From: Speakman, Glenn - Oxfordshire County Council
<Glenn.Speakman@Oxfordshire.gov.uk>
Sent: 06 May 2022 11:47
To: James Kirkham; DC Support
Cc: Transport CDC Minor
Subject: 21/00922/OUT Land West Of Foxden Way Great Bourton OX17 1QY

Planning application:	21/00922/OUT
Location:	Land West Of Foxden Way Great Bourton OX17 1QY
Description:	OUTLINE Planning Application with all matters reserved save for access for up to 9 First Homes
Case Officer:	James Kirkham

In our previous response to this application, we objected to the granting of planning permission. The application has since been amended. I have assessed how the updated plans impact our previous reasons for objection:

TITLE
PROPOSED SITE ACCESS JUNCTION WITH VISIBILITY SPLAYS

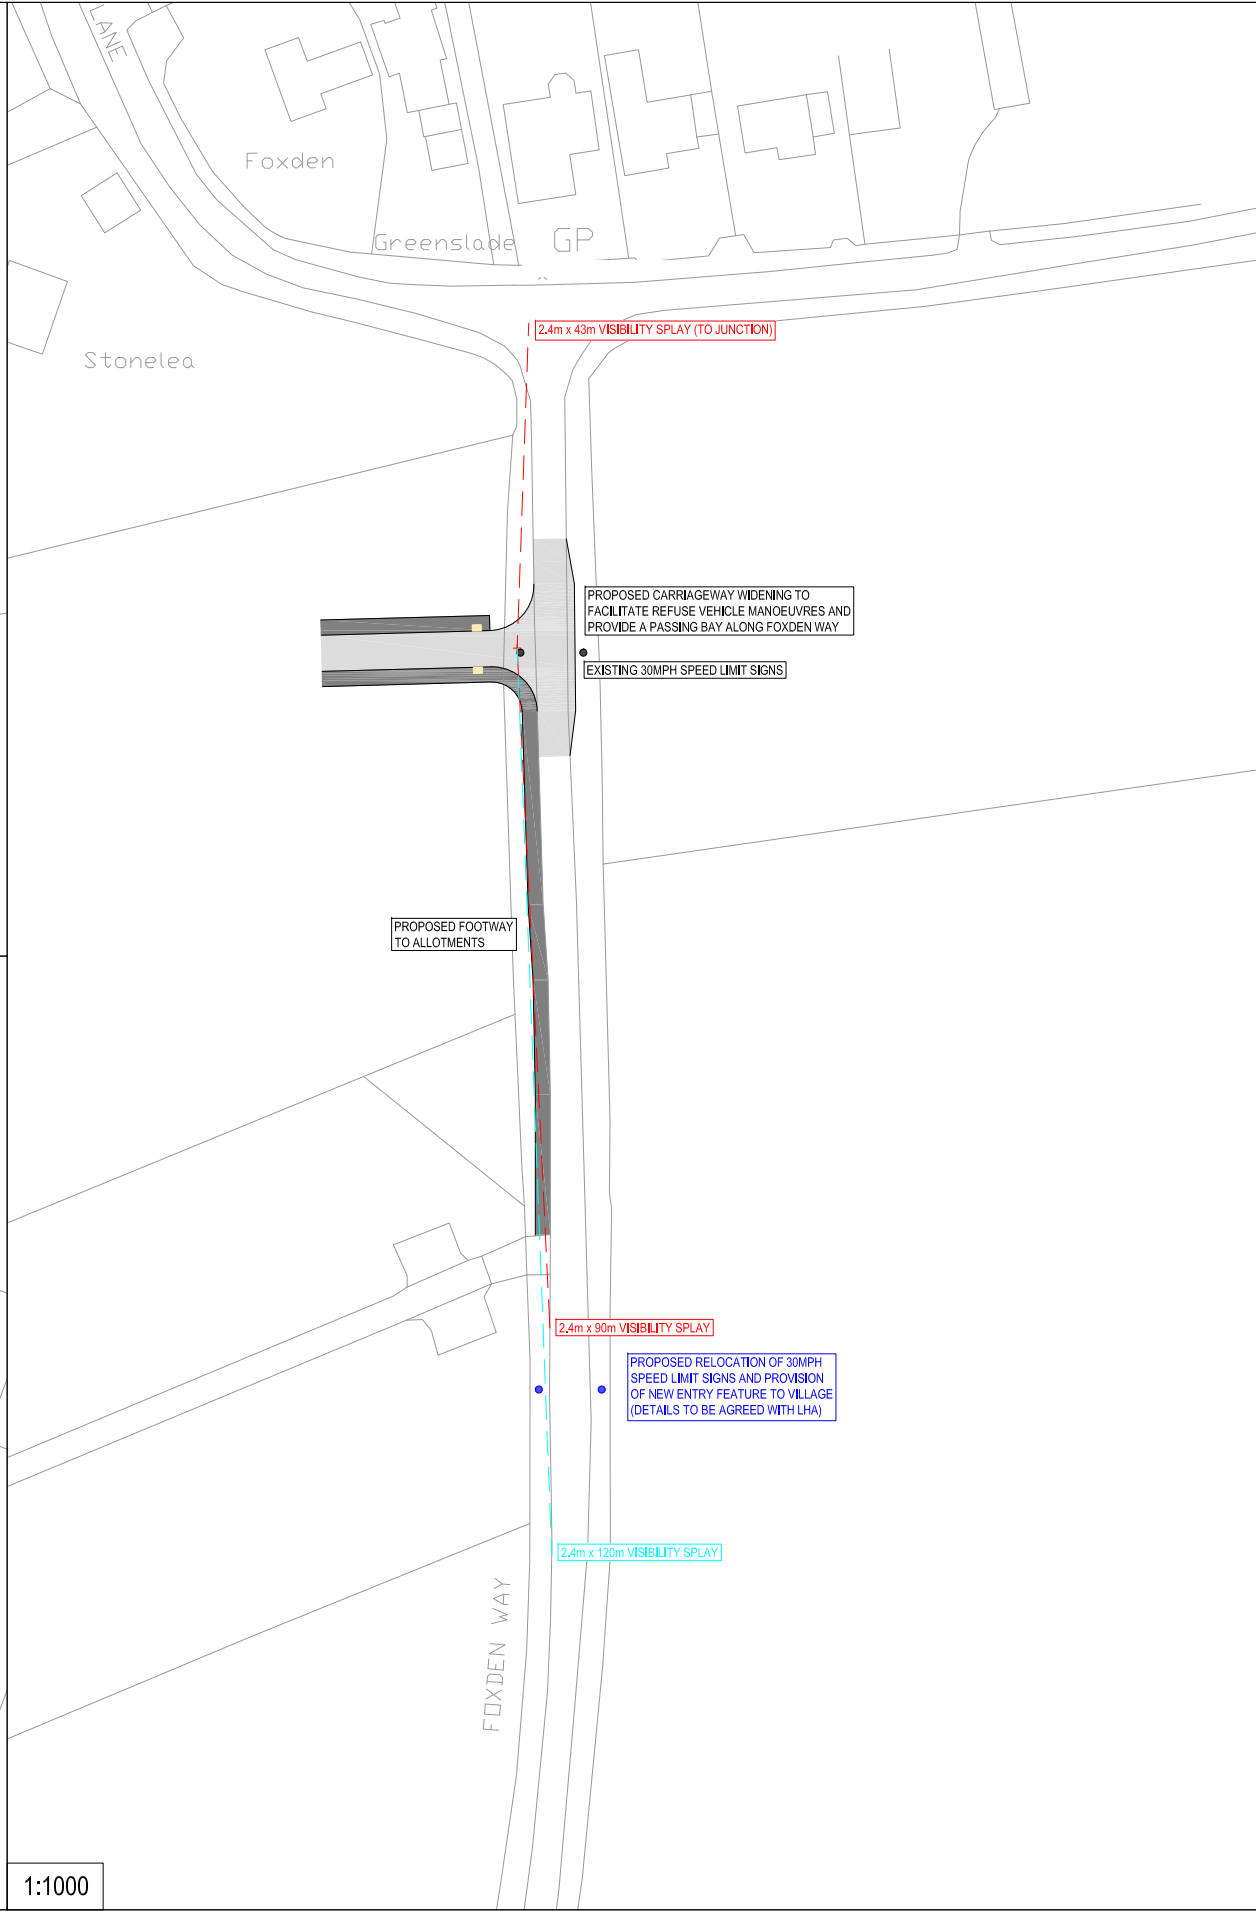
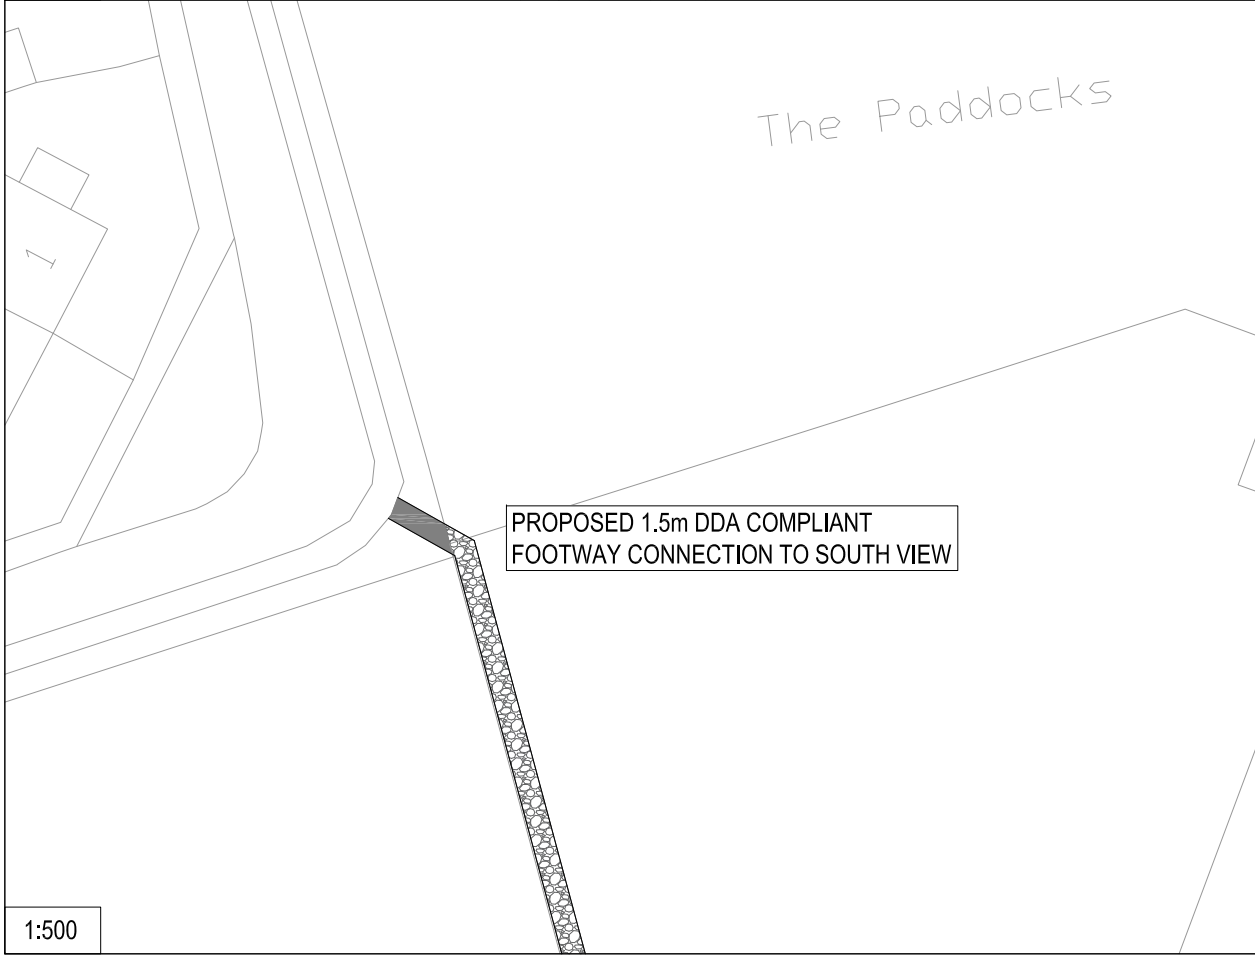
Vision splay calculation: The vision splays are considered acceptable. The northern splay can demonstrate visibility reaching the school lane junction. The southern splay is shown as 90m but it is clear that a longer splay is attainable as set out in the transport note. The relocation of the 30mph road signs will require a consultation.

PROJECT NO.	DRAWING NO.	REV
T21512	002	C

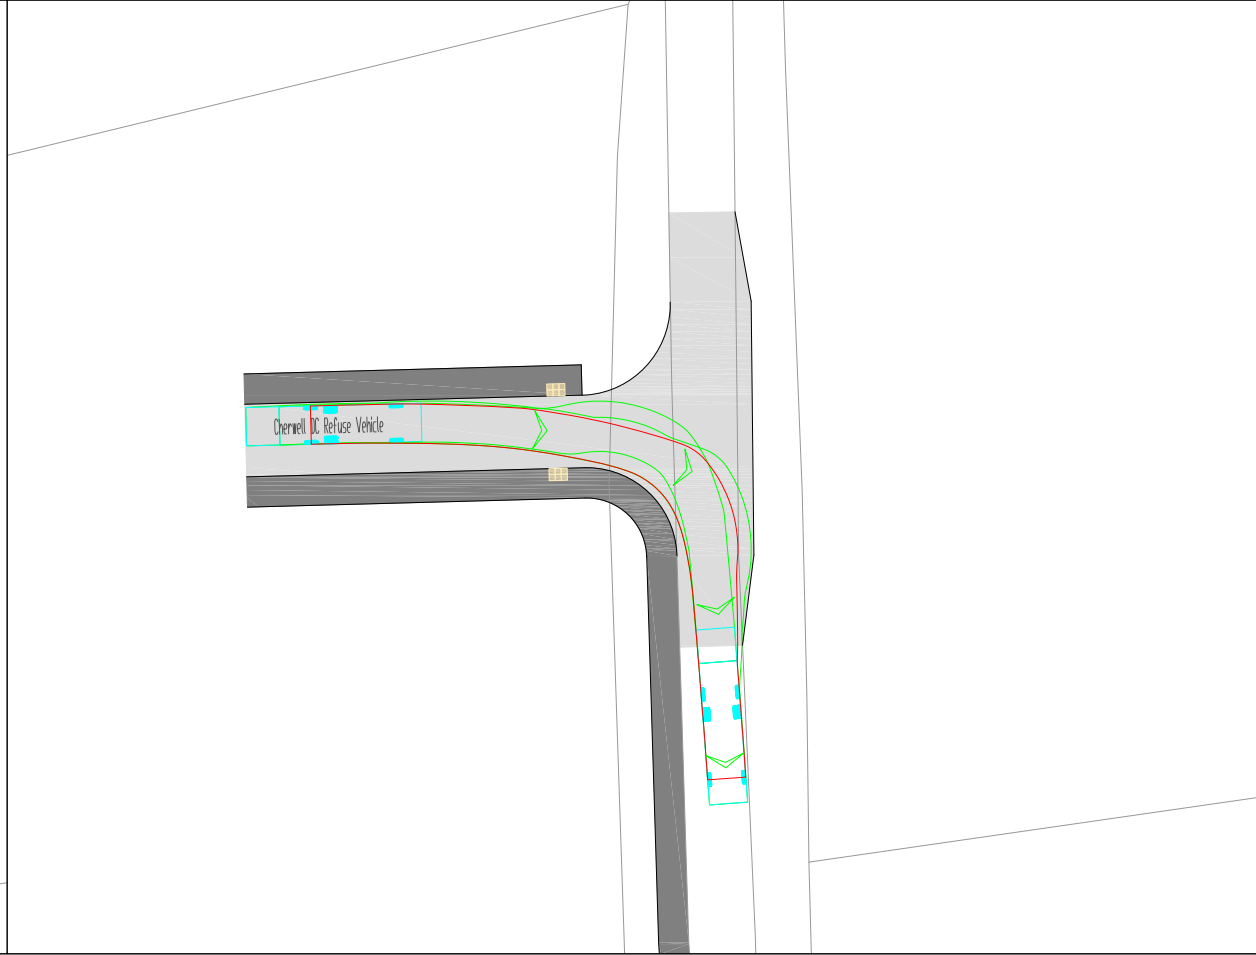
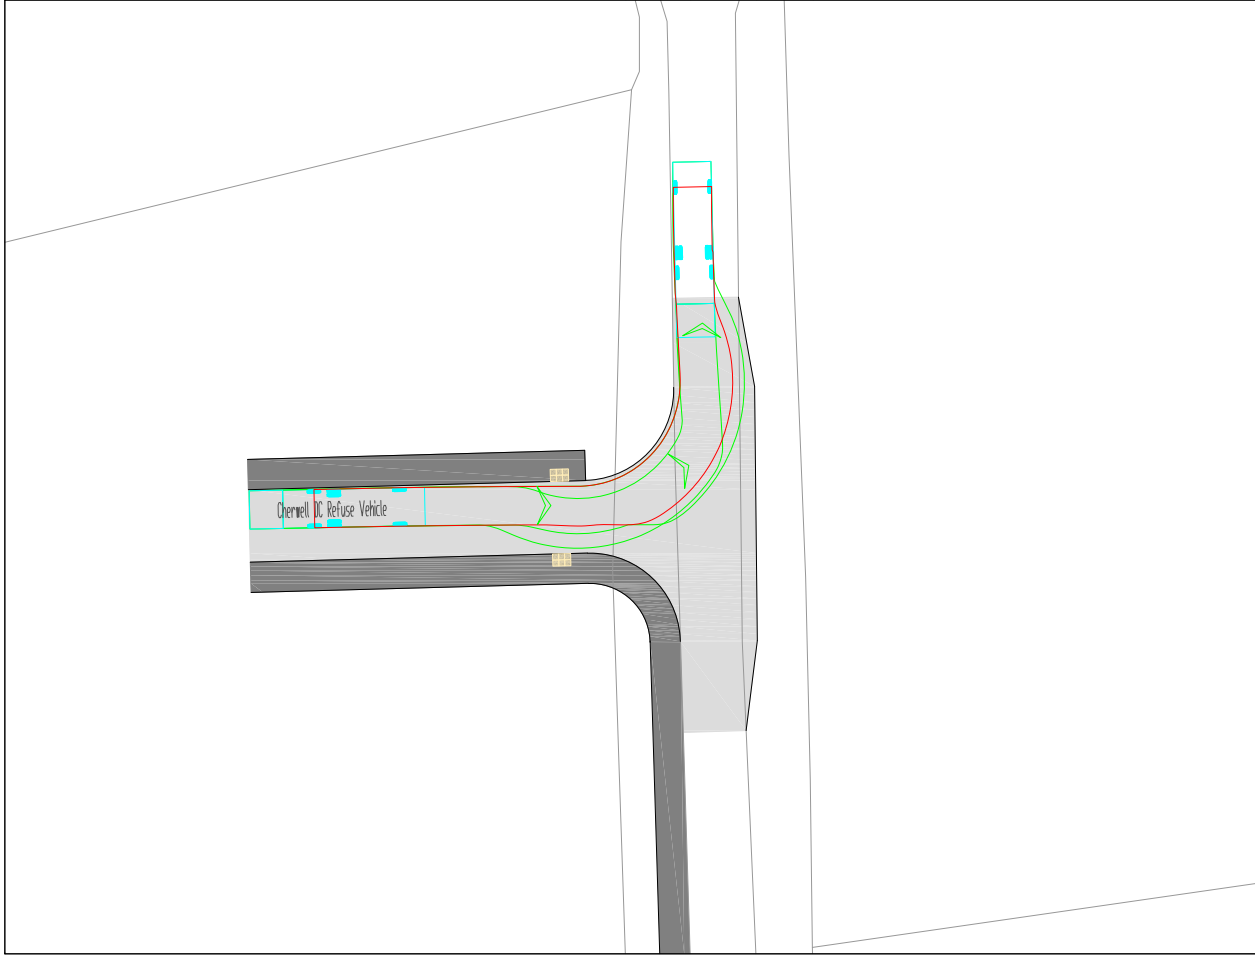
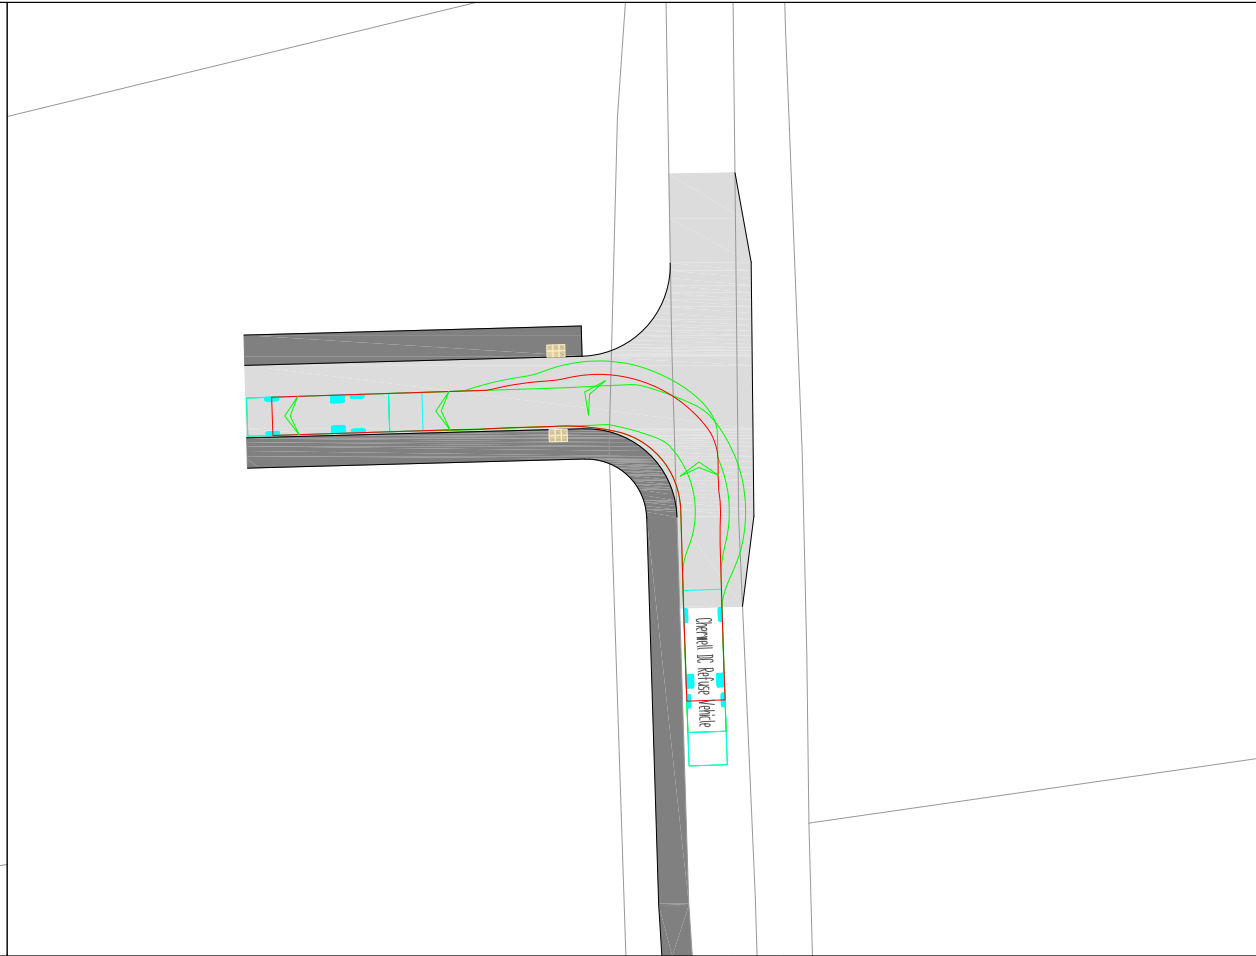
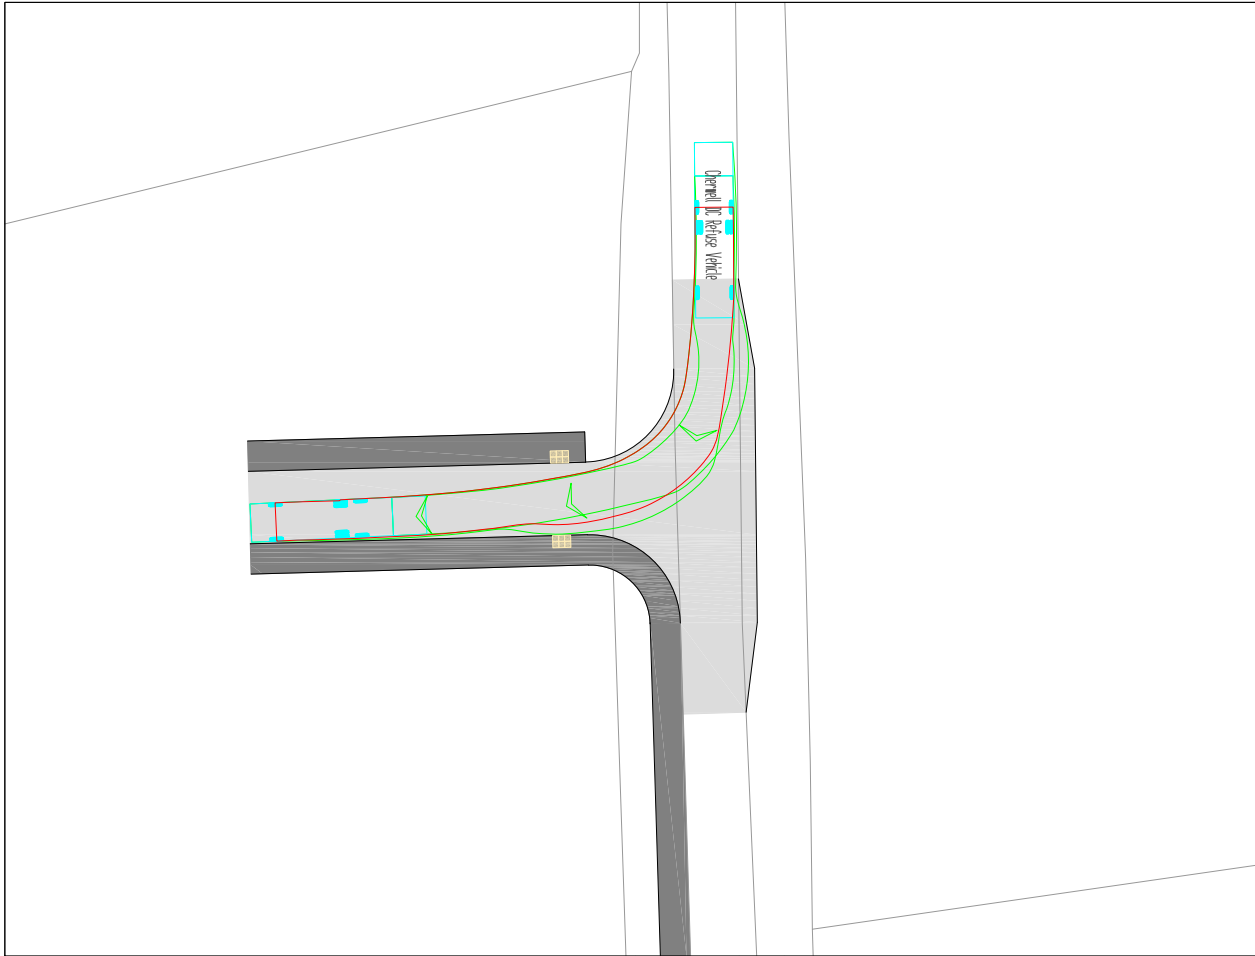
Swept path analysis: The updated swept path analysis shows an 11.6m long refuse vehicle successfully accessing and egressing from the site via the proposed vehicular access in a forward gear.

Vehicle overrun: This issue will be solved by the localised widening of Foxden Way at the proposed site access.
